Engineers Comments Regarding Surface Water Drainage

Application Reference:	LU/157/26/PL	Reviewer Reference:	ADC/EXT5/AF
Planning Officer:	Hebe Smith	Date of Review:	22/09/2026
Site Name:	Wick Football Club Crabtree Park Coomes Way Littlehampton BN17 7LS		
Application Description:	Change of surface from grass to artificial turf and erection of new 2.5m acoustic fencing. This application is in CIL Zone 2 (zero rated) as all other development.		
Assessment Number:	2

Appendix M
Overland Flows
JPP Consulting drawing no. 31285-FRA04

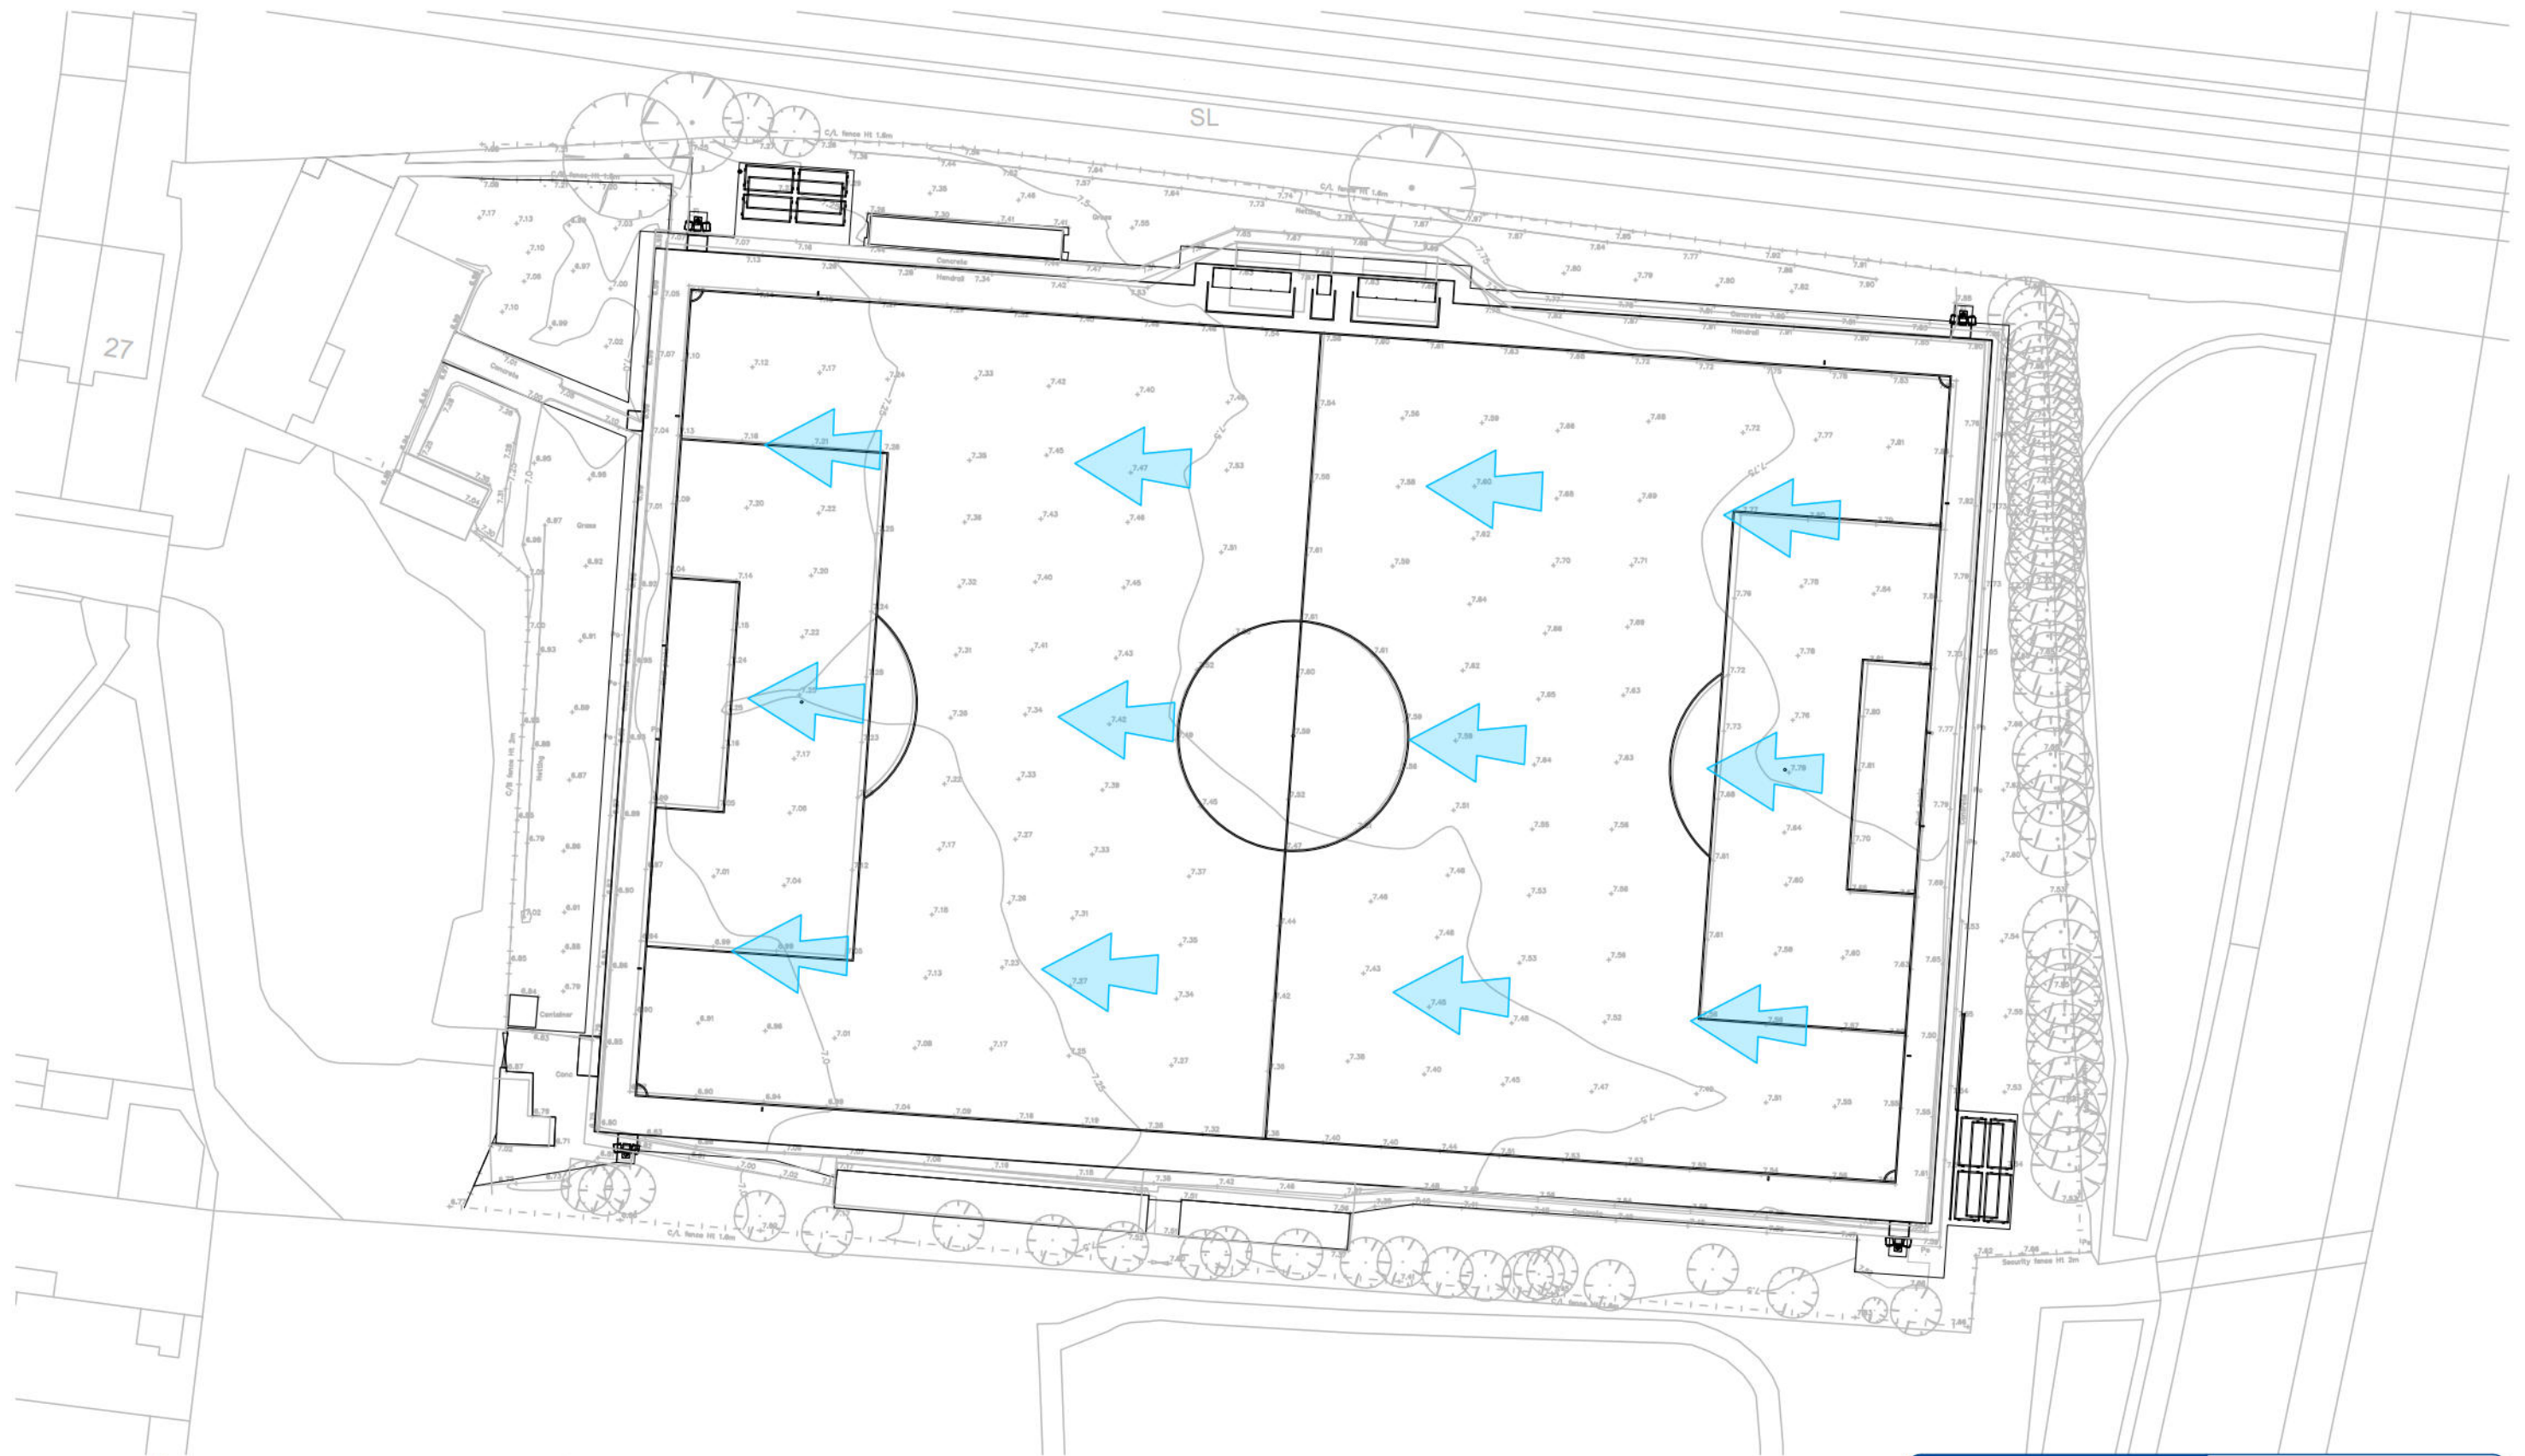
- 3.4. The ability of the downstream sewer to accept the flows should be confirmed through capacity check.
- 3.5. Whilst it is noted the risk is low due to the use of permeable paving, the exceedance paths should be updated to include the carpark design and to demonstrate where exceedance flows leave the site without flowing towards the existing building.
